**From:**  
**Sent:** 27 June 2024 18:05  
**To:** Nick Hirst  
**Cc:** DCAdmin  
**Subject:** Planning Application 2024-91236 - Poor Design  
**Attachments:** poor\_design.pdf

The plan, for plots 34 and 35, shows the retaining wall, which sits between the two dwellings.

Detail
PLANNING LAYOUT - PLOTS 23, 34/35

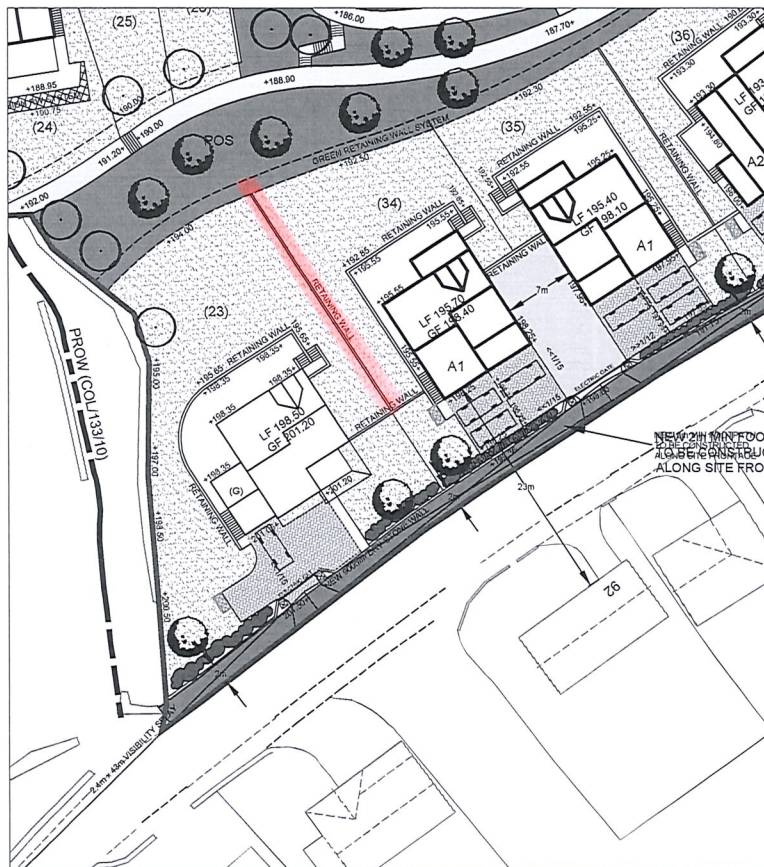
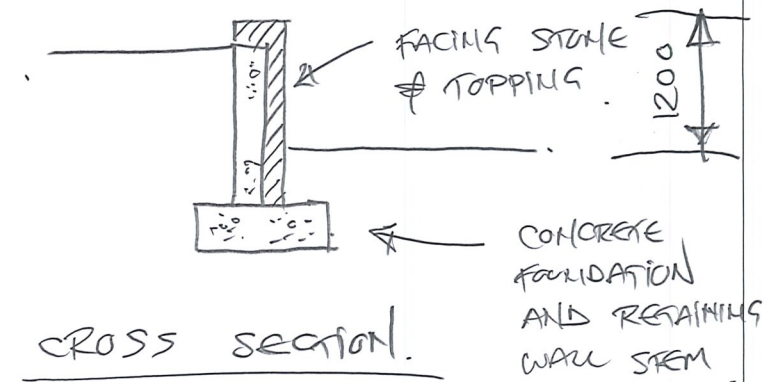
However, it is in a different place to where the supporting information document shows it.

The image below indicates where the plans place the wall (red oval), and where the supporting information shows it (green lines).

For example, the retaining wall is going to be either stone, or glass; dependent upon which document you read, or even which part of the same document.
